Application number: 2024/90339	
What is the application for?:	Erection of part two storey and part single storey front, side and rear extensio
Address of the site or building:	19, Cheviot Way, Upper Hopton, Mirfield, WF14 8HW
Postcode:	WF14 8HW

PROPOSED BLOCK PLAN
1:500

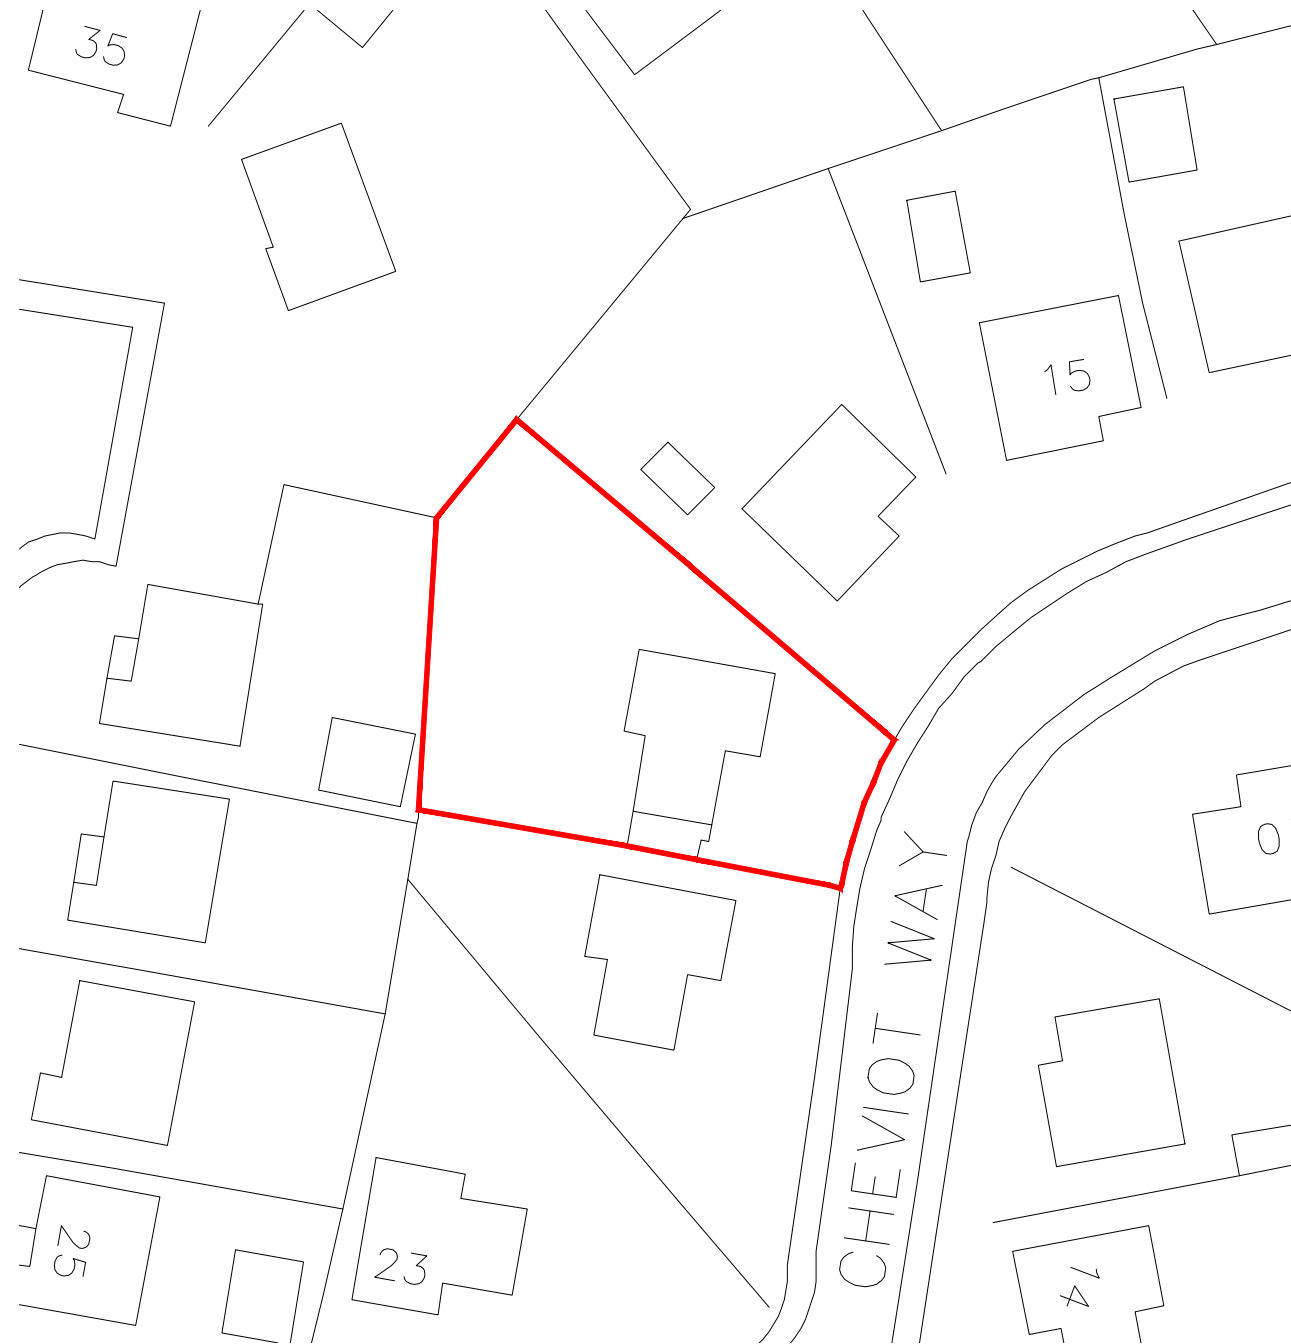
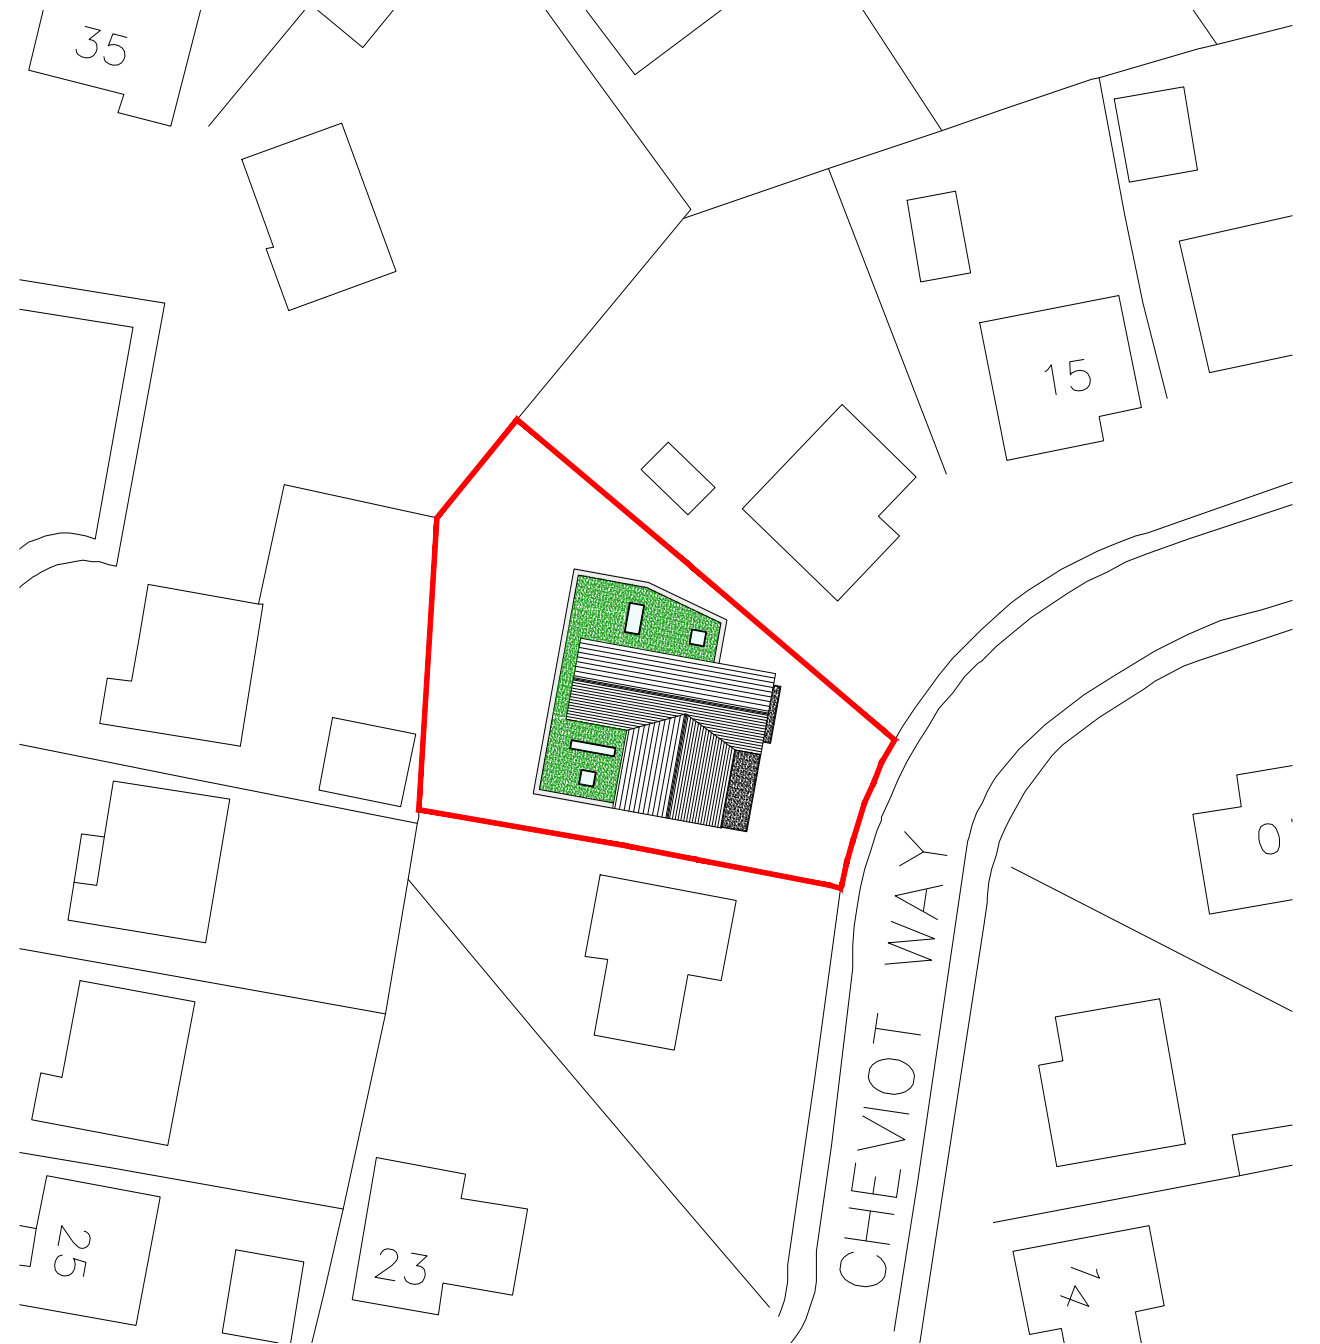
Type of comment: An objection	
Do you wish your comments to be published on the website anonymously?	Yes
Further to the amended plans being submitted, please consider our objections below: Firstly, even though the plans have been updated, the block plan is still not accurate and does not show Despite the wraparound balcony and terrace being removed, the proposed plans will still have an overwhelming impact on residential amenity in Cheviot Way. It will result in an extensive lack of privacy, leave us entirely overlooked and with a considerable loss of natural light. The proposed development will bring the habitable rooms in the property to within 10 metres of the boundary fence. From our calculations, reducing what is currently c20m house to house to nearer 14m. We will lose almost all privacy in our garden and property and will be completely overlooked. The steep topography of the gardens will exacerbate this even further. It will also significantly reduce our direct sunlight for a large part of the year as we currently only get light in summer from that side as we have a large tree with a TPO in our garden. Overall, the scale and the design of the application is out of keeping with the estate and will have a negative impact on the character of the area. It should also be noted than in a village with a conservation area, less than 5 mins walk away, the outdoor green space of the property will significantly reduce and be vastly out of proportion to the proposed dwelling. As per our objection to the original plan, we still consider that the proposal is contrary to a number of policies within the local plan and request that the application is refused.
